3 Pleasant Ave Amendment App & Fast Track

From: John Shields <jshields1@maine.rr.com>
To: "Laurie Leader" <lr@portlandmaine.gov>
Cc: "Bob Gaudreau" <Bob@hardypond.com>
Date: Mon, 23 May 2016 12:31:01 -0400
Subject: 3 Pleasant Ave - Revision No 4

Drawing
FIRE ALARM & SMOKE/CO DETECTOR PLANS

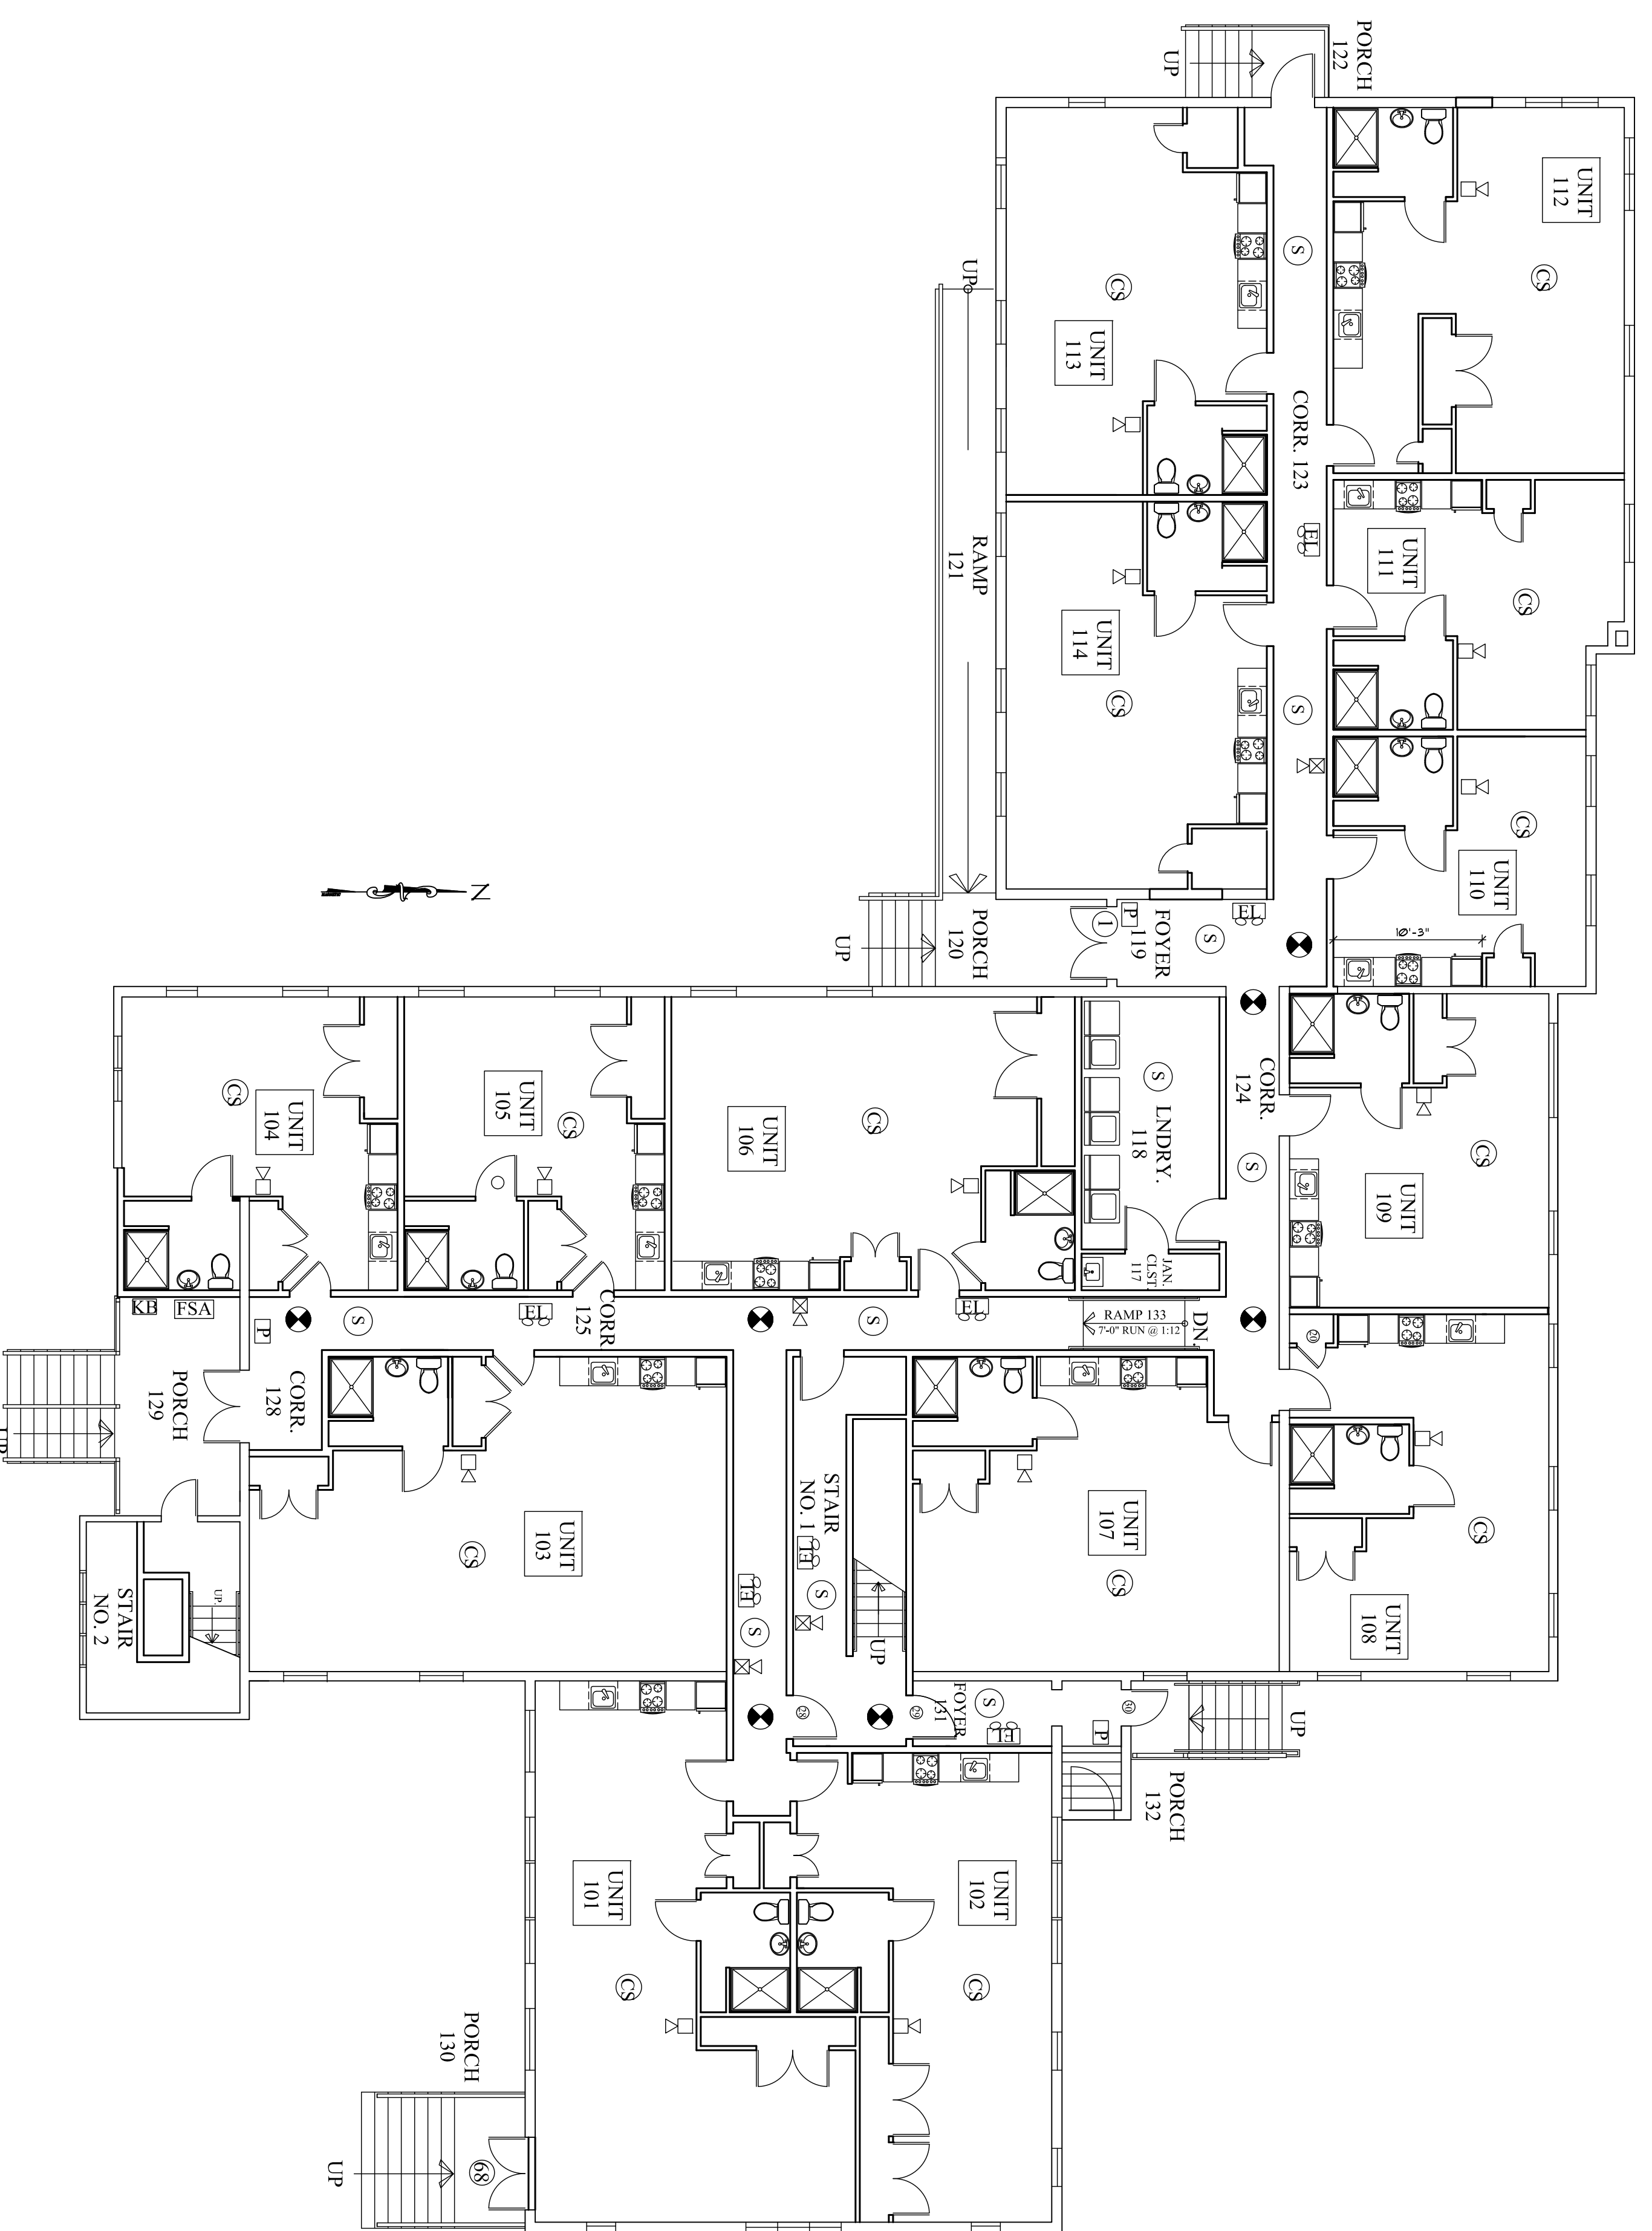
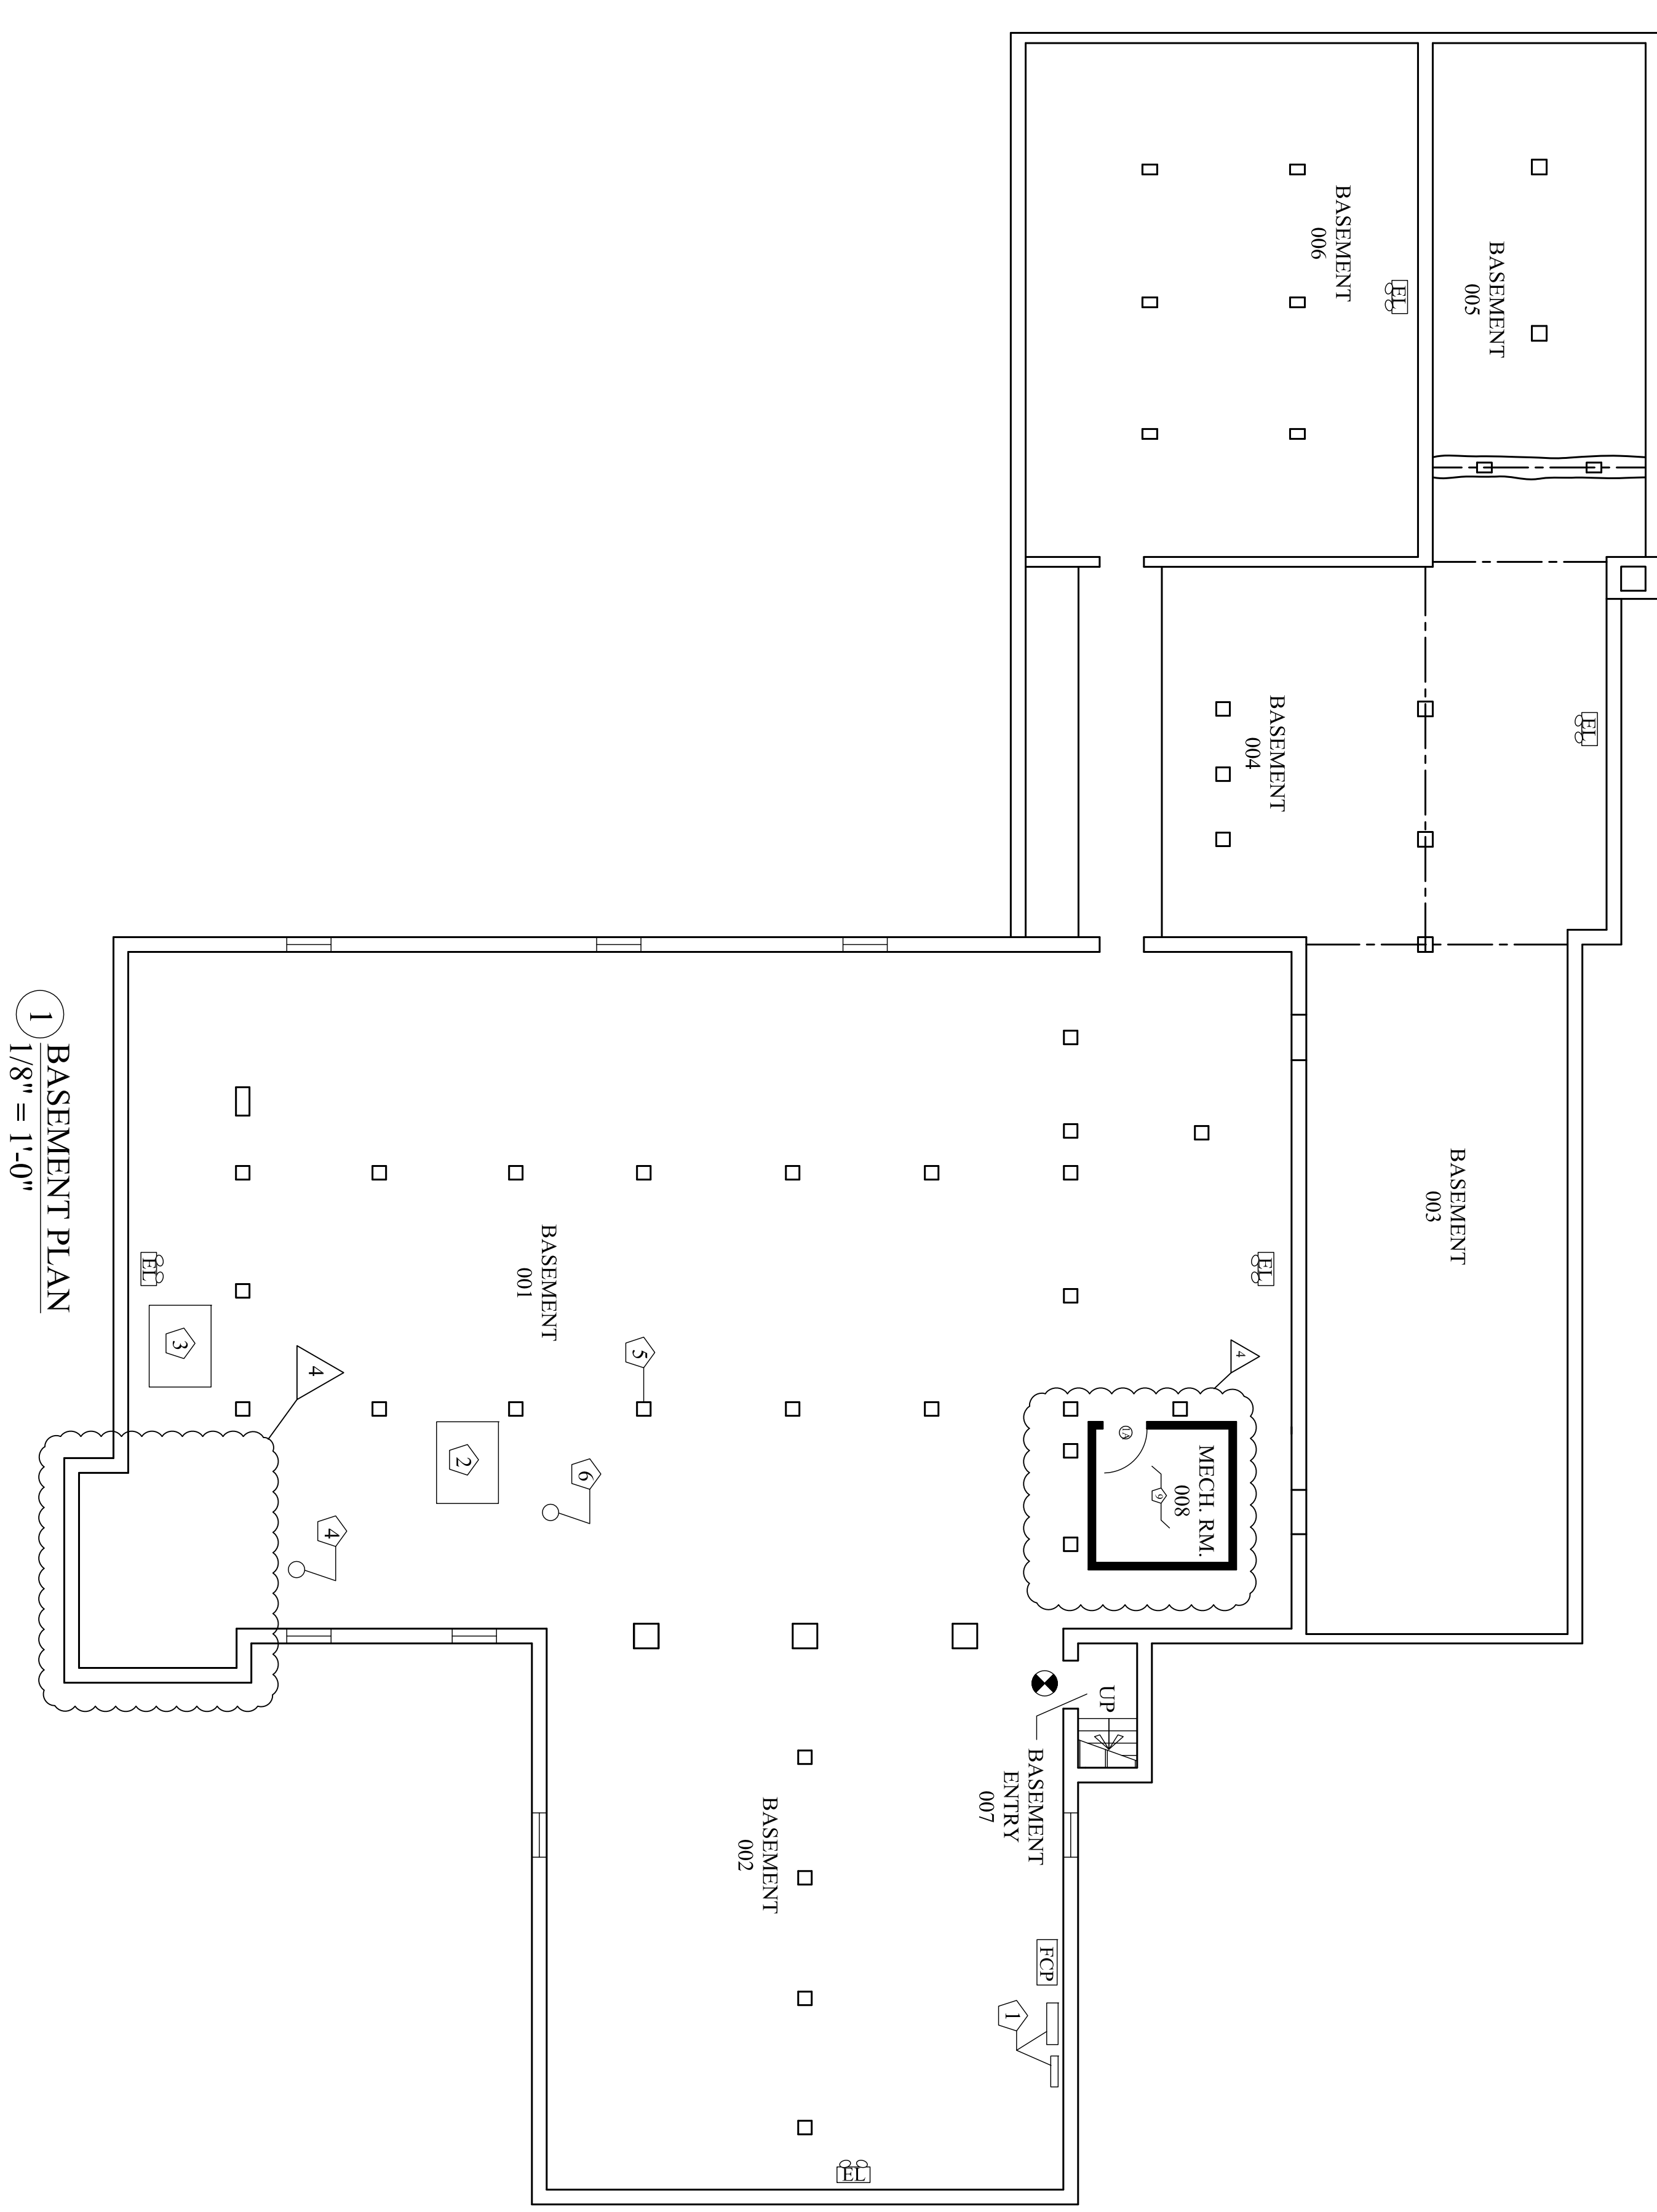
10. Drawing A-16 Fire Alarm & Smoke/CO Detector Plans: Basement Plan revised to show Mechanical Room 008 location.
11. Drawing A-17 Life Safety Plans: Basement Plan revised to show Mechanical Room 008 location.
